Recommendation Report for Planning Permission

REF NO:	BR/175/20/PL
LOCATION:	23 Mead Lane Bognor Regis PO22 8AP
PROPOSAL:	Change of use from Student Accommodation to 3 no. dwellings, comprising 1 no. one bed apartment, 1 no. two bedroom house and 1 no. three bedroom house (resubmission of application BR/99/20/PL). This application may affect the setting of a listed building & affects the Upper Bognor Road & Mead Lane Conservation Area.

PROPOSED ELEVATIONS

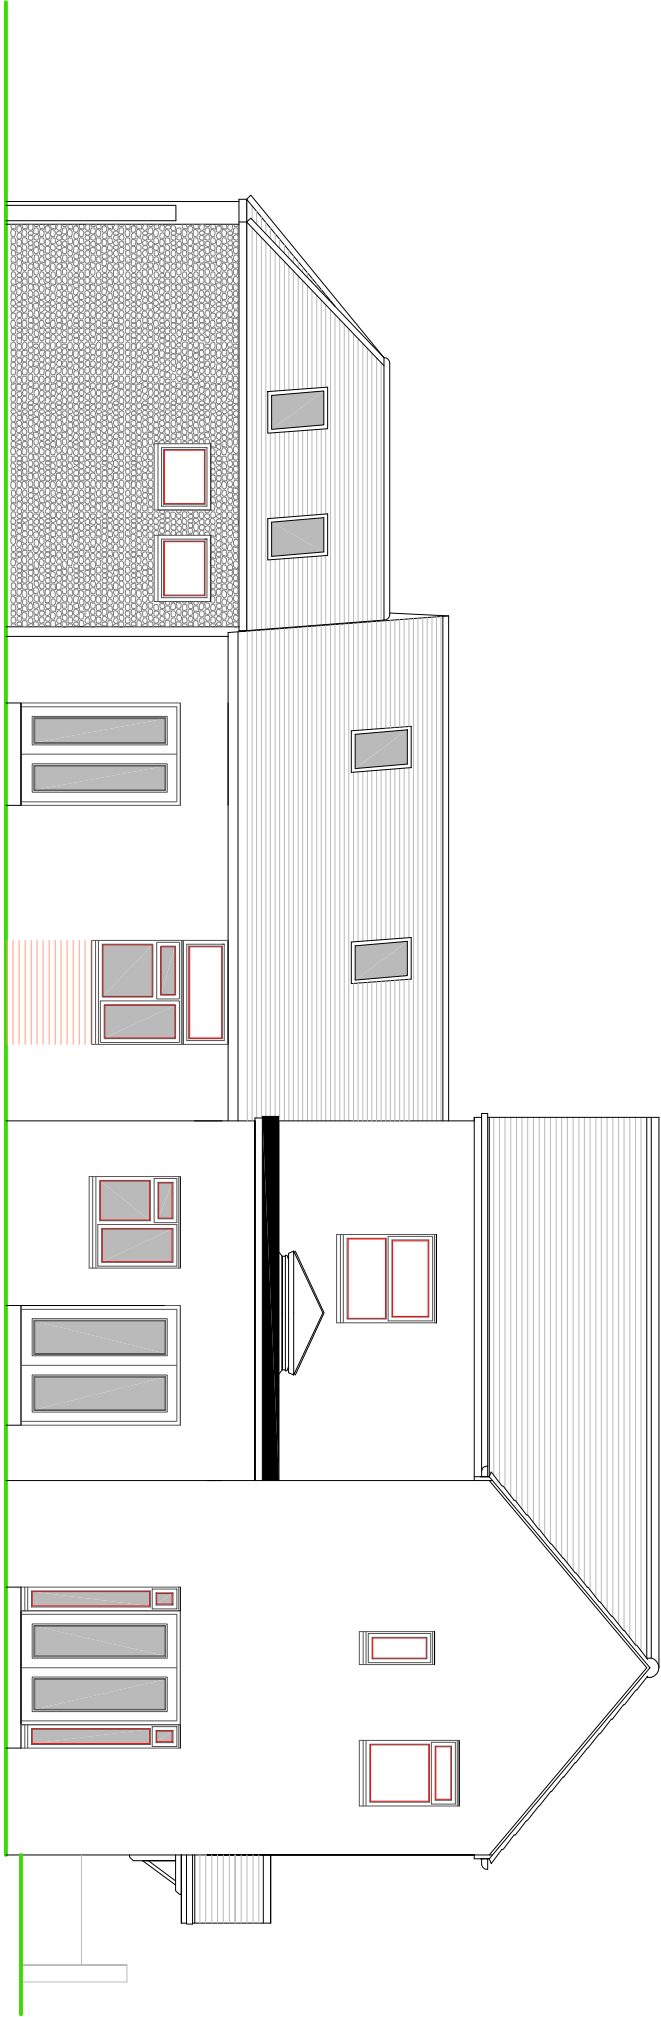
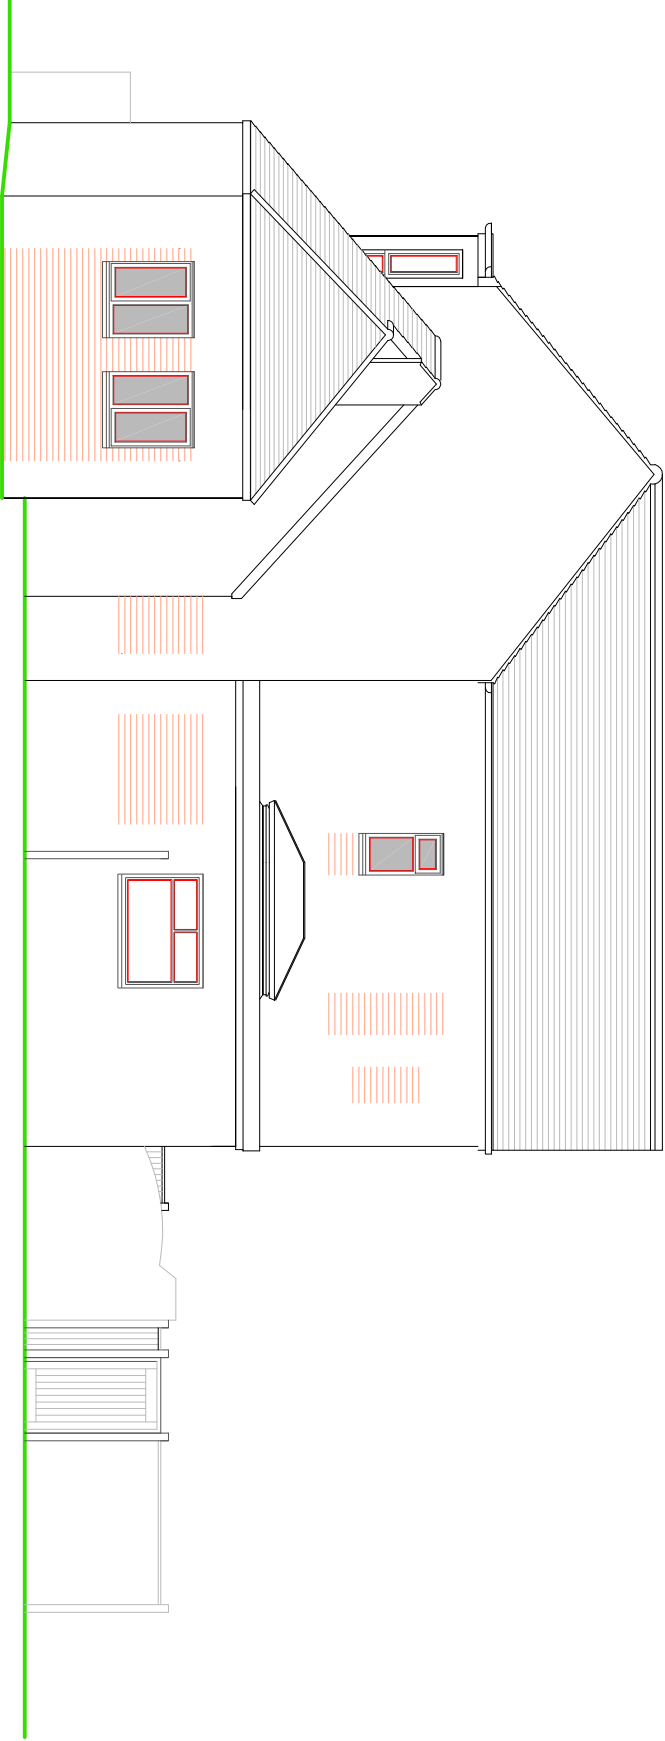
Having regard to the layout of unit 3 and the lack of non obscured windows and openings the proposed conversion would give rise to an unsatisfactory environment for the occupiers in conflict with policy QE SP1 of the Arun Local Plan.

The layout of unit 3 is such that the living room is no longer the only room provided with an outlook. The bedroom windows are no longer proposed to be obscure glazed. This provides a better environment for future occupiers. The proposal would therefore comply with policy QE SP1 of Arun Local Plan which seeks to ensure that development does not have a significantly negative impact on residential amenity.

To counter these reasons for refusal the glazing to windows in the east elevation has been amended to delete reference to obscure glazing, a parking capacity assessment of the local area has been prepared by Paul Basham Associates (transport consultants), which identifies the available capacity on the local road network and the application is also supported by a draft legal agreement, which is now completed.

PROPOSED CYCLE STORAGE

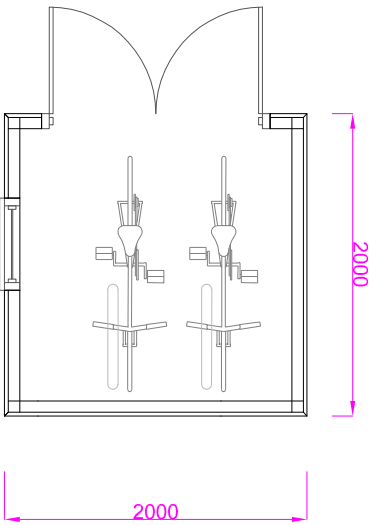
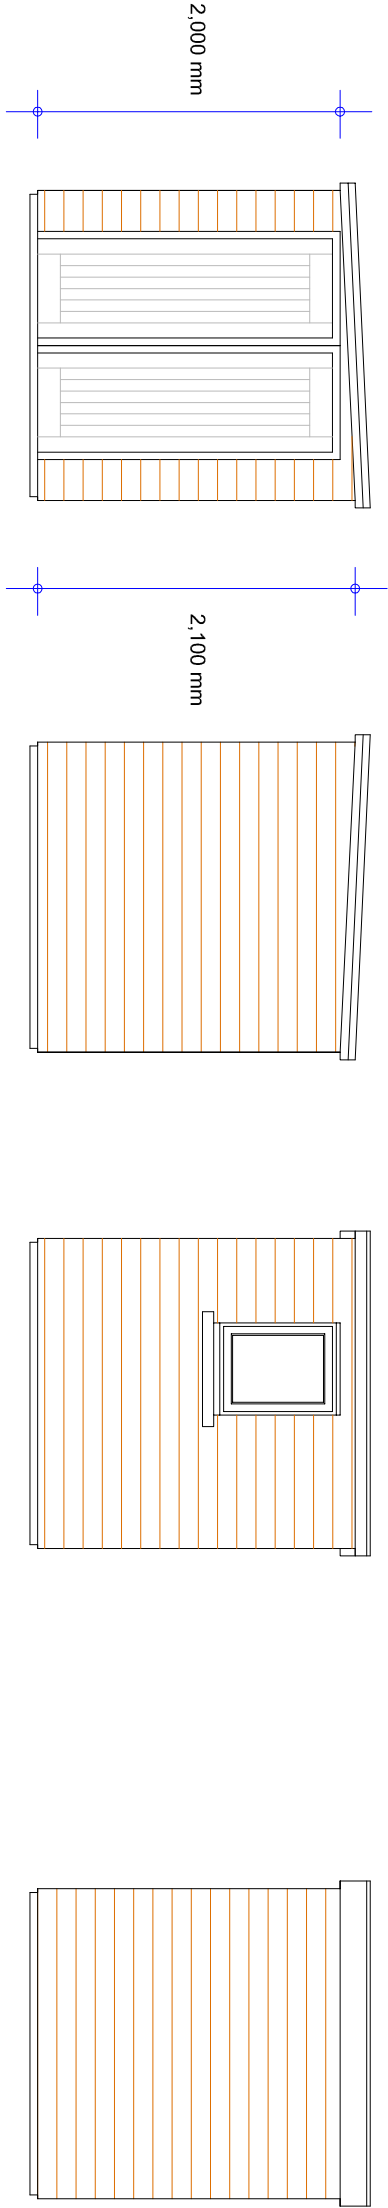
In terms of cycle parking, each dwelling will be provided with a cycle shed, with space for at least two

cycles. As such, this proposal meets the Arun parking requirements for cycle parking. The inclusion of secure and covered cycle parking will promote the use of sustainable alternative modes of transport to the private car and provision is conditioned.
